Application For: SP2025-00090 – SITE PLAN DFT

SITE PLAN

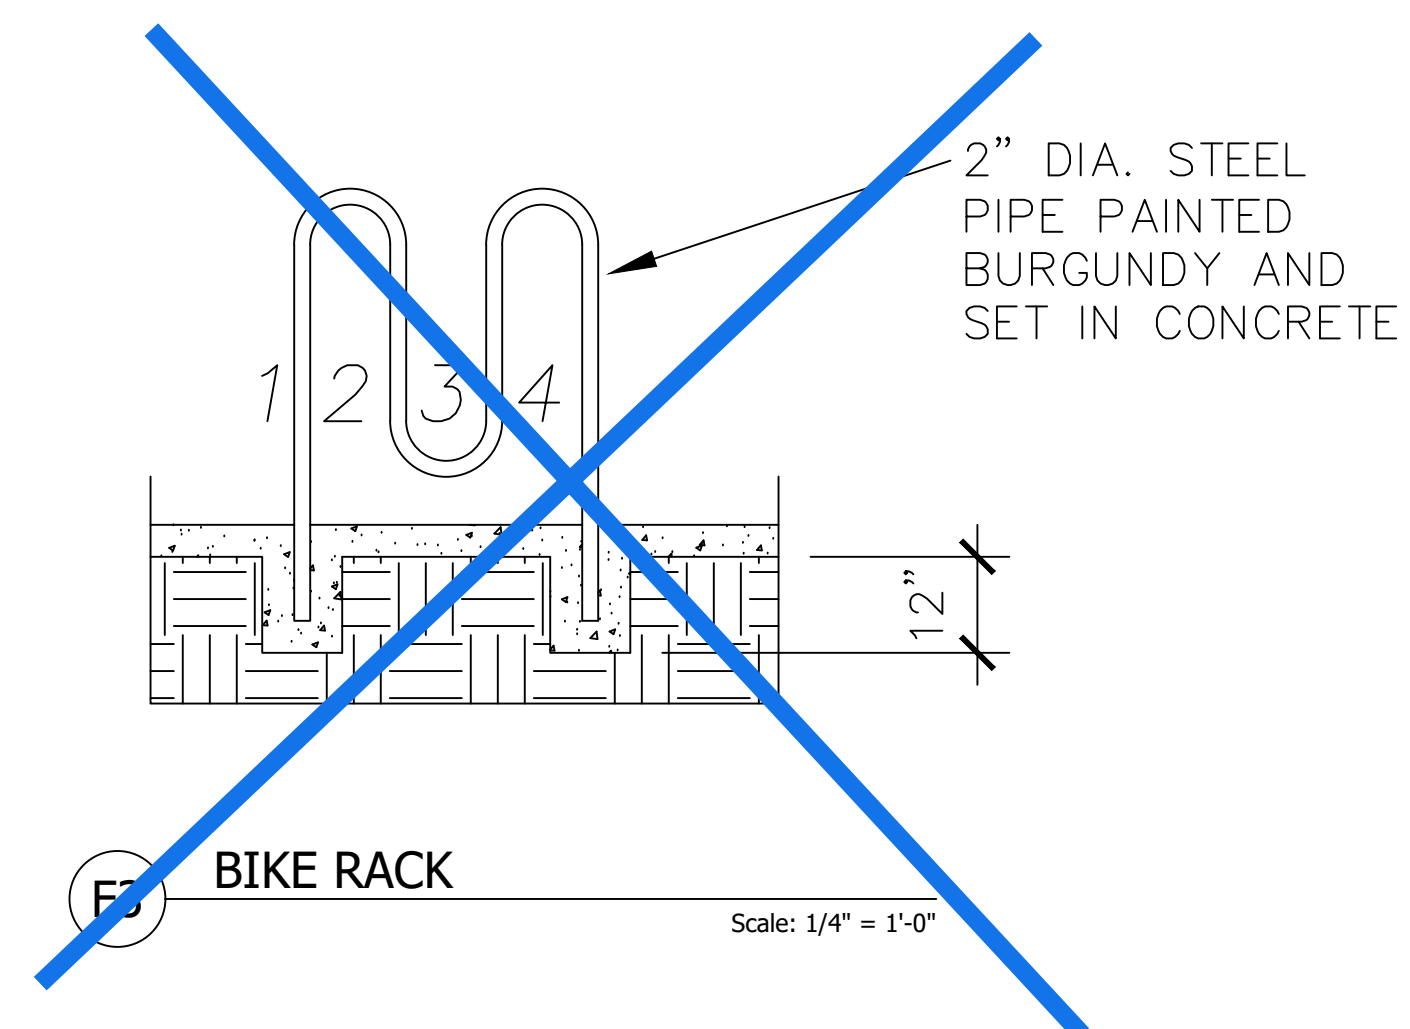
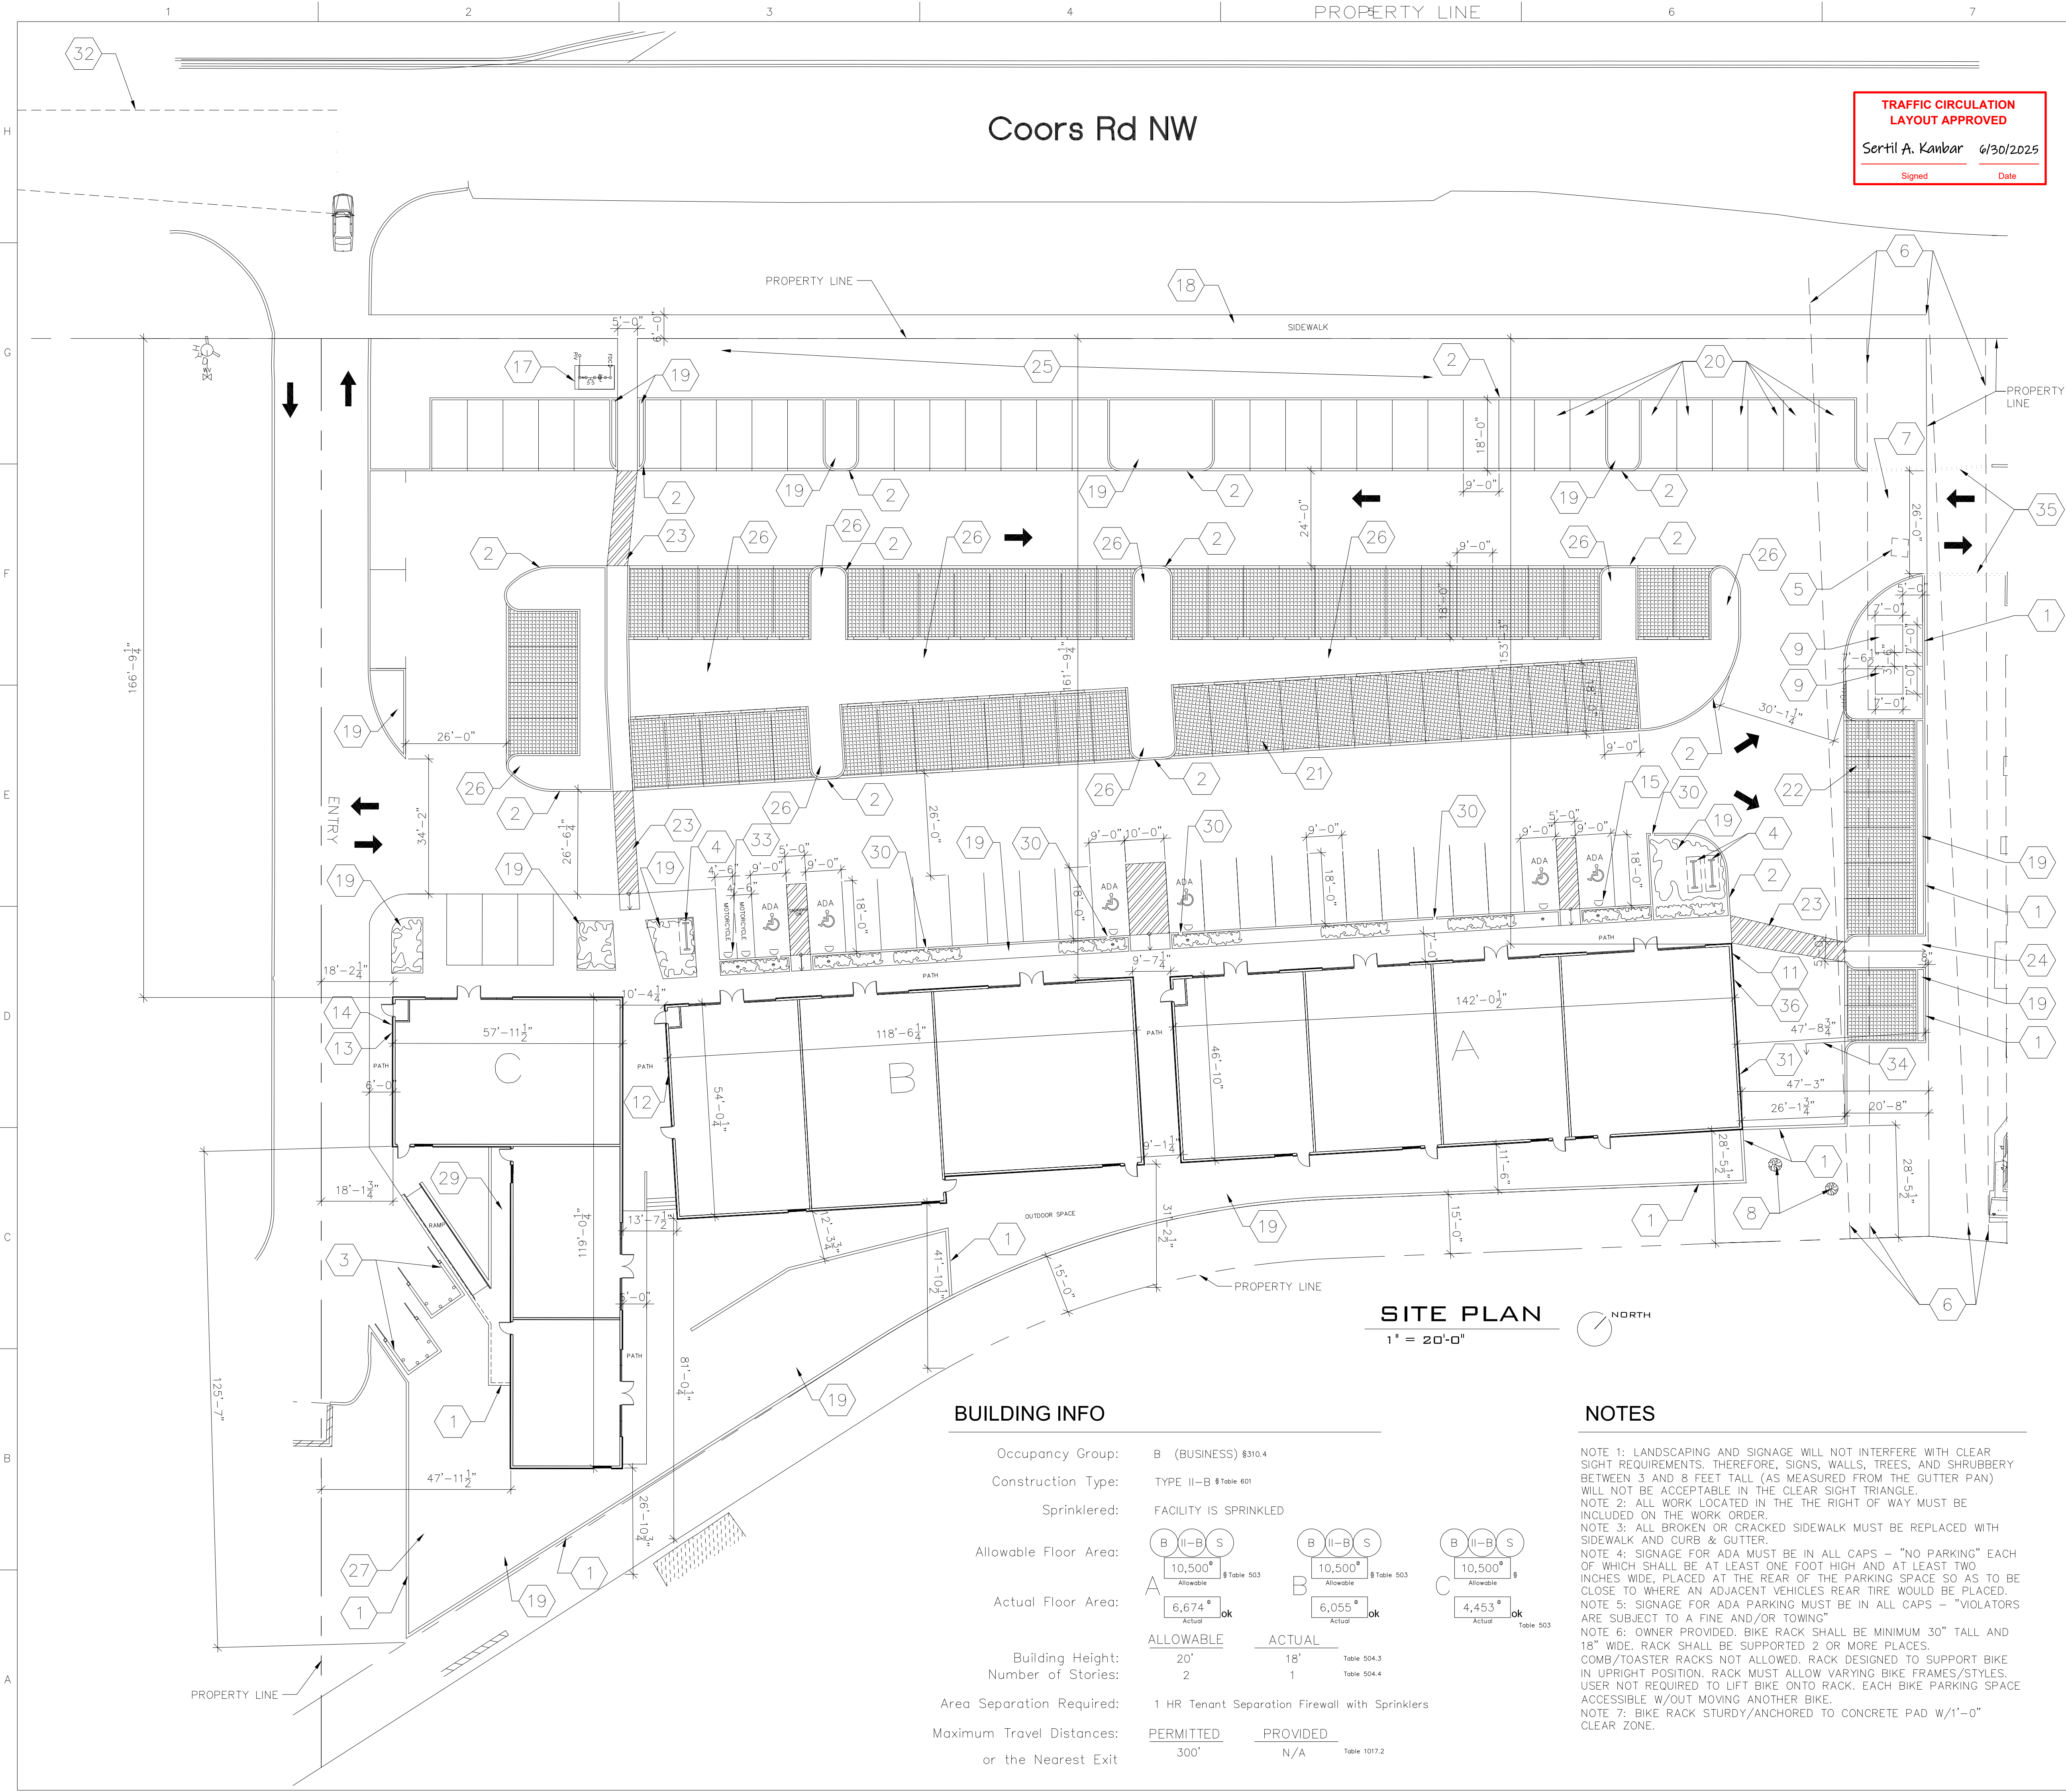
2. Parking: Need to clarify parking calculations, providing type of tenant businesses planned. If unknown, then you can use Office/ General Retail, at 3.5 spaces/1000 sq ft as your basis and calculate parking requirements based on square footage to be supplied. Please keep in mind that if you allow restaurants, that parking rate goes up to 5.6 spaces/1000 sq ft, and Personal and Business Services is 4 spaces/1000 sq ft, so plan accordingly to ensure adequate parking.

1 motorcycle parking space added. Located on south entry point in front of building C. Parking Calculations updated to reflect B Occupancy Group. Drawing is uploaded as **AS101_Rev1**.
